From: Laura Gibbons <Laura.Gibbons@arun.gov.uk>
Sent: 13 July 2021 14:55
To: Planning.Responses <Planning.Responses@arun.gov.uk>
Cc: Simon Davis <Simon.Davis@arun.gov.uk>
Subject: RE: Planning Re-Consultation on: AL/59/21/DOC

Condition 10- surface water drainage design

Application No: AL/59/21/DOC
Registered: 25th May 2021
Site Address: Springfield Hook Lane Aldingbourne PO20 3TE
Grid Reference: 493480 104546
Category: Discharge of Condi
Description of Works: Approval of details reserved by condition imposed under AL/64/20/PL relating to conditions 9-foul drainage, 10-surface water drainage, 11-flows discharge & 12-maintenance & management of surface water drainage.

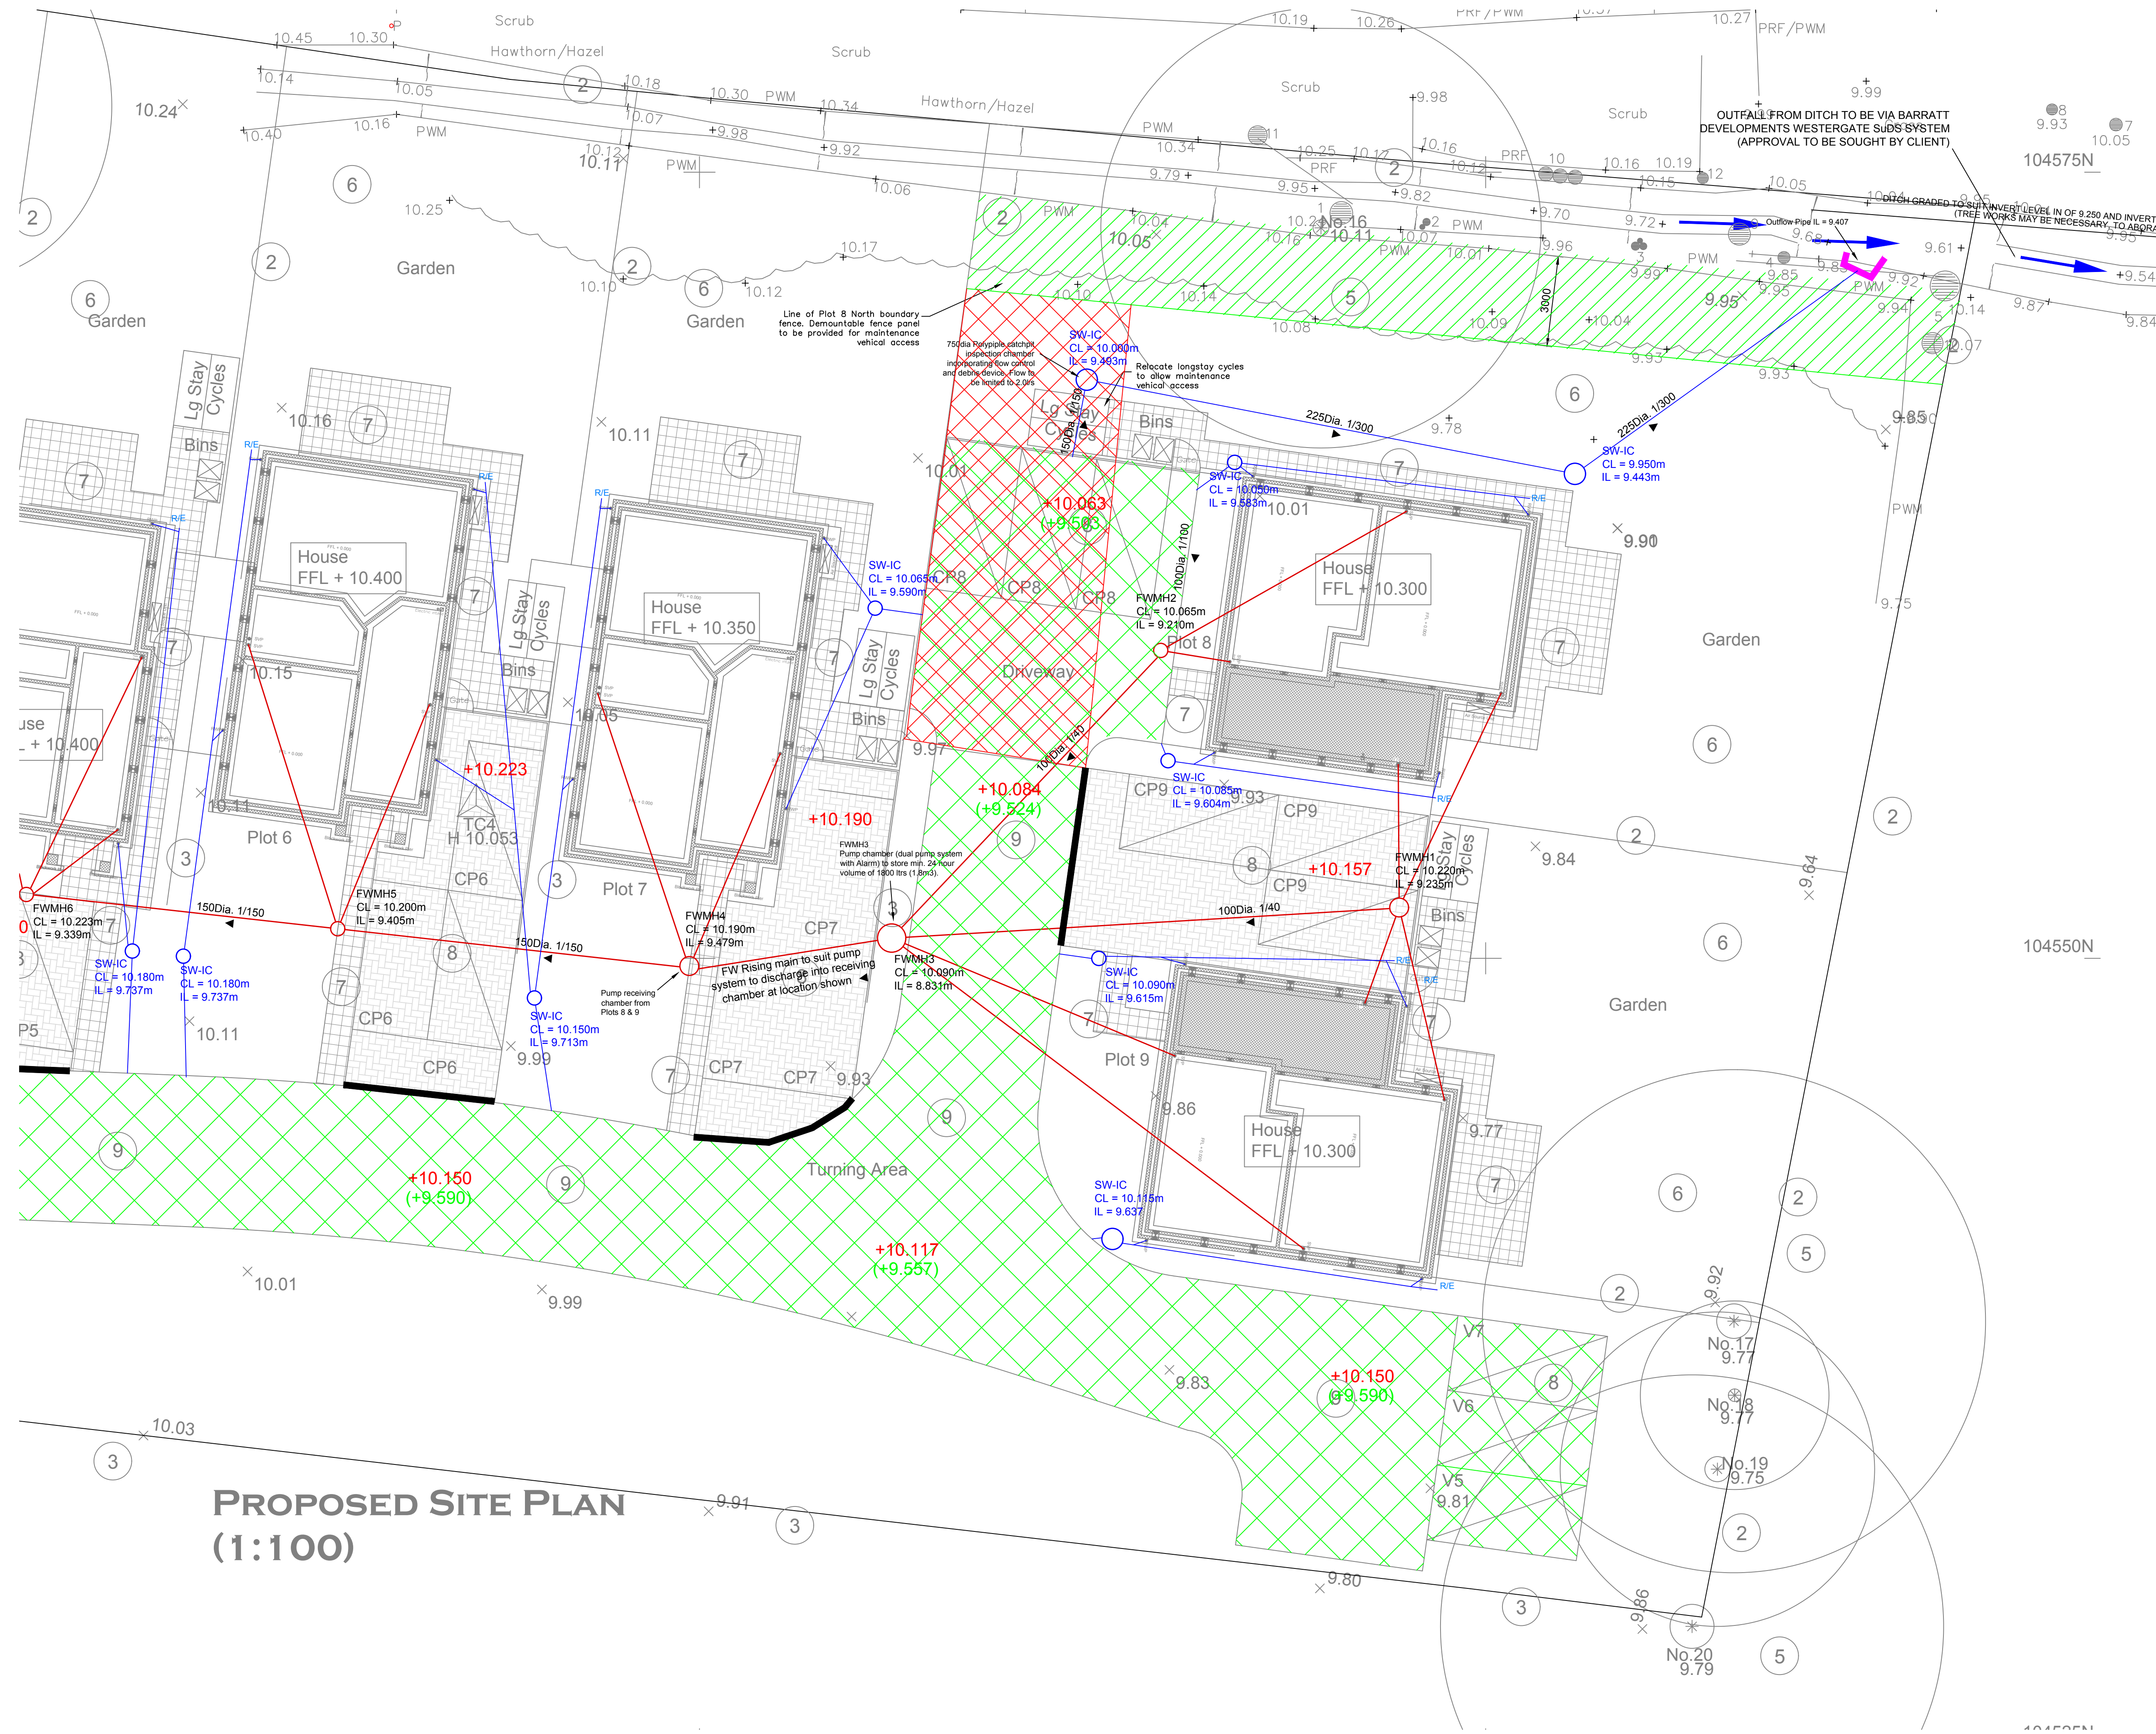
4. Invert levels of all pipes connecting into the permavoid need to be detailed on plan. As well as the outlet level.
5. Catchpits are required upstream of all connections into the permavoid/ sub-base, this requirement should be clearly shown on plan.

7. It needs to be indicated on plan where the section drawing relates to as road levels vary throughout the site.
8. Can driveways be redesigned to have a fully permeable make up linking to the sub-base of the road to provide greater storage and treatment at source? Rather than having to rely upon proprietary treatment devices.

9. A site specific construction detail drawing of the hydrobrake chamber is required.
10. The fall of the pipe from the permavoid to the ditch is insufficient. All pipes must achieve 1m/s self cleansing velocity. I haven't been able to scale off your plan (as I do not have access to a plotter today) to examine the slope of the permavoids/sub-base, but is there potential to slacken this at all?

11. Please label all pipes with diameter and fall.
12. I note that the invert level of the ditch outlet has now been established. As detailed by Paul previously "*The existing ditch re-grading is noted, however, your topo survey needs to extend all the way to where the ditch outfalls into Barratts suds system via an existing 300mm pipe. Information should include the invert level of their pipe and any existing trees on route that may interfere with regrading this ditch to the desired levels. We can then have a further discussion in terms of what can be achieved. Existing trees are known to be growing in the ditch bed and will no doubt require discussions with an arboriculturist and possibly our tree officer.*" We need to have this information and complete these further discussions to establish for certain what outlet level is acceptable from your site.

DETAIL A - SECTION THROUGH PERMEABLE ACCESS ROAD INCORPORATING POLYPIPE PERMAVOID SUB-BASE REPLACEMENT ATTENUATION SYSTEM
SCALE 1:15

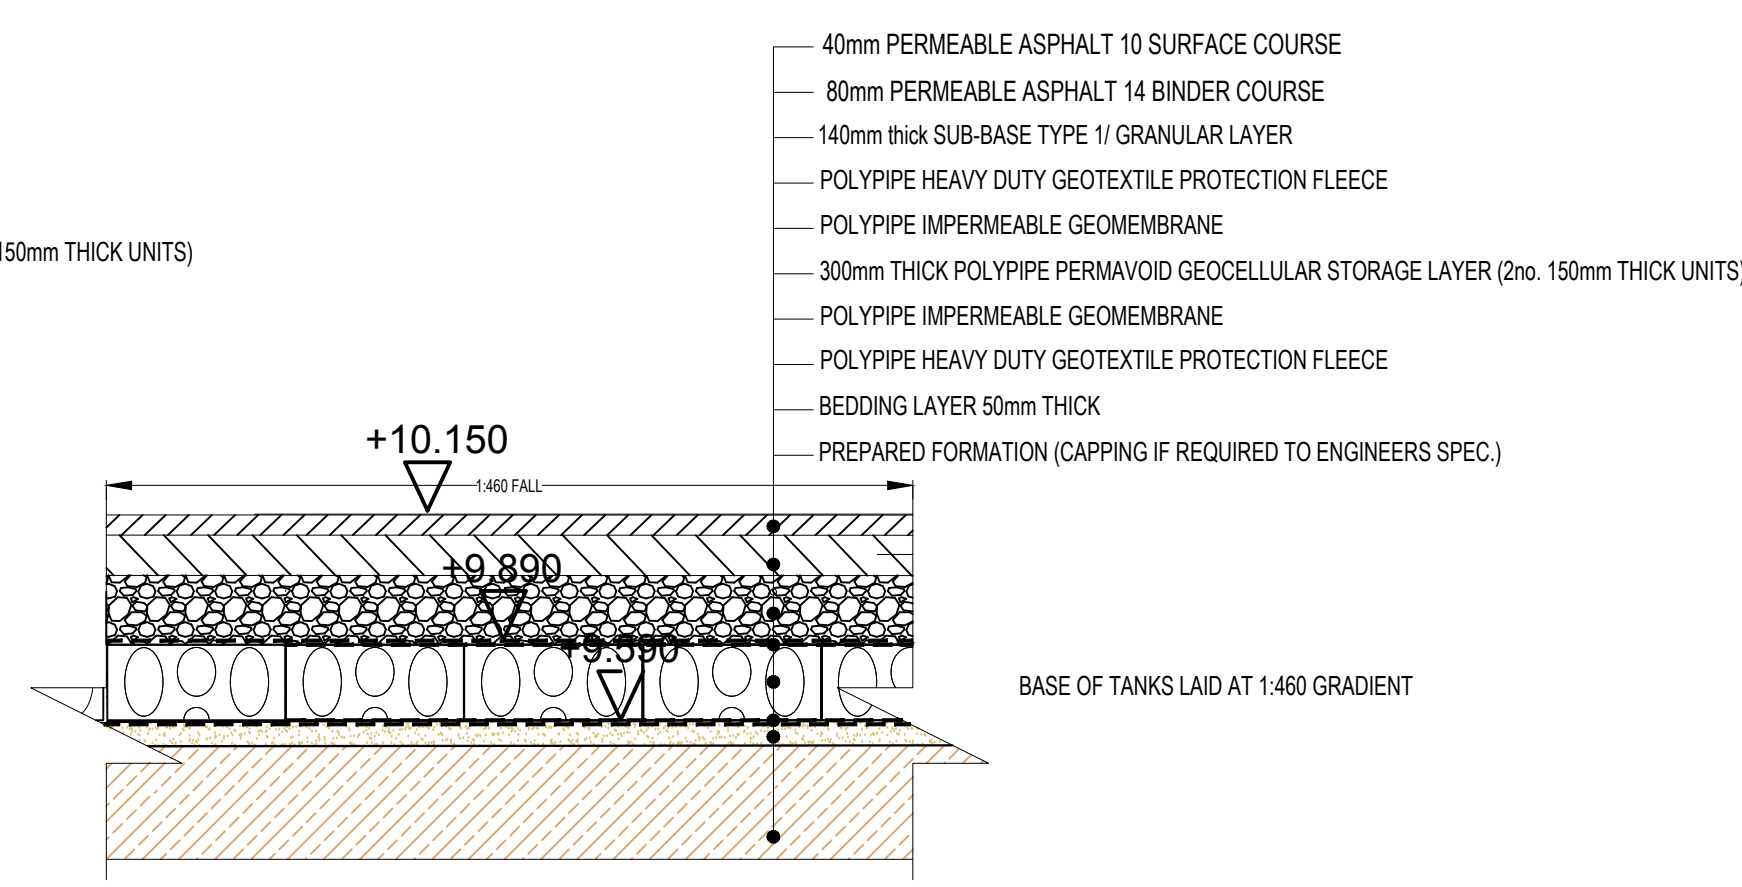
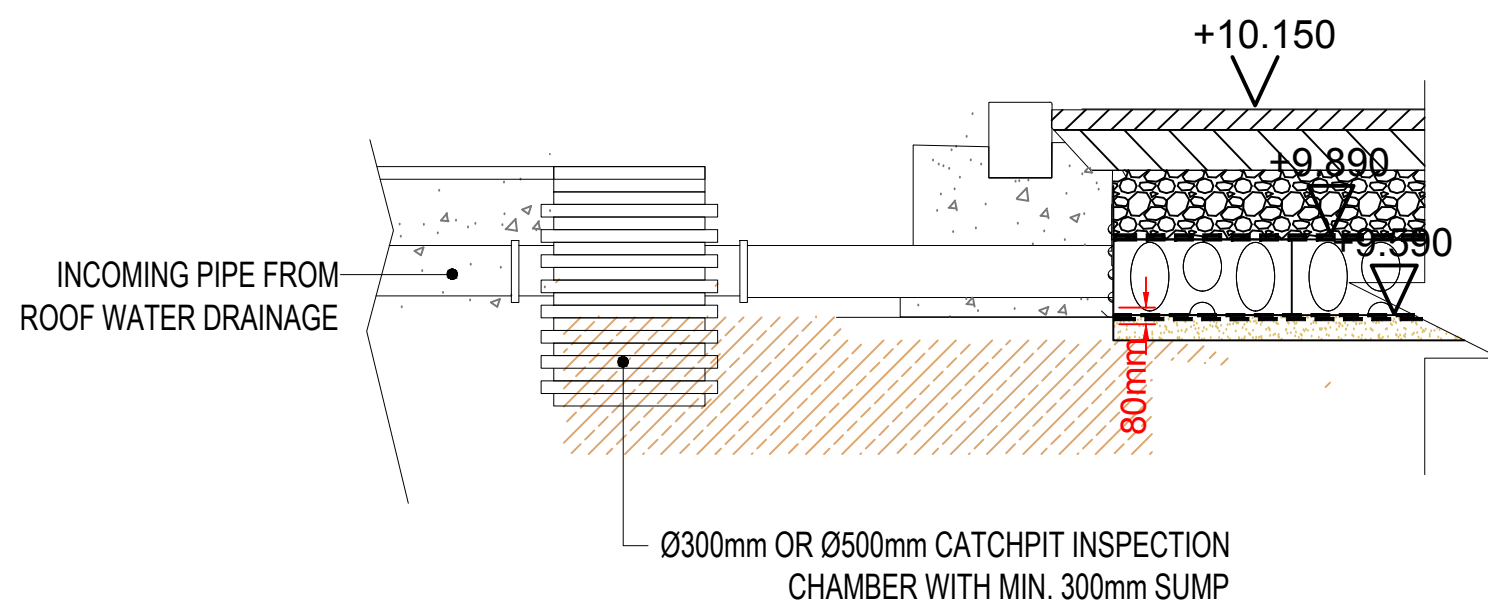
6. The proposed road make up is very confusing- permeable asphalt is proposed over type 1 (not permeable) which receives water from permachannels. The type 1 then overlies the permavoid tanks which are detailed to be fully encapsulated in an impermeable liner. This simply does not work, provide a permeable link between the road surface and permavoids must be provided. Please provide a permeable sub-base material, e.g. type 3, and a permeable geotextile fully wrapping around the crates. If an impermeable liner is required this should be around the base of the tanks and then up the sides of the tank and sub-base.
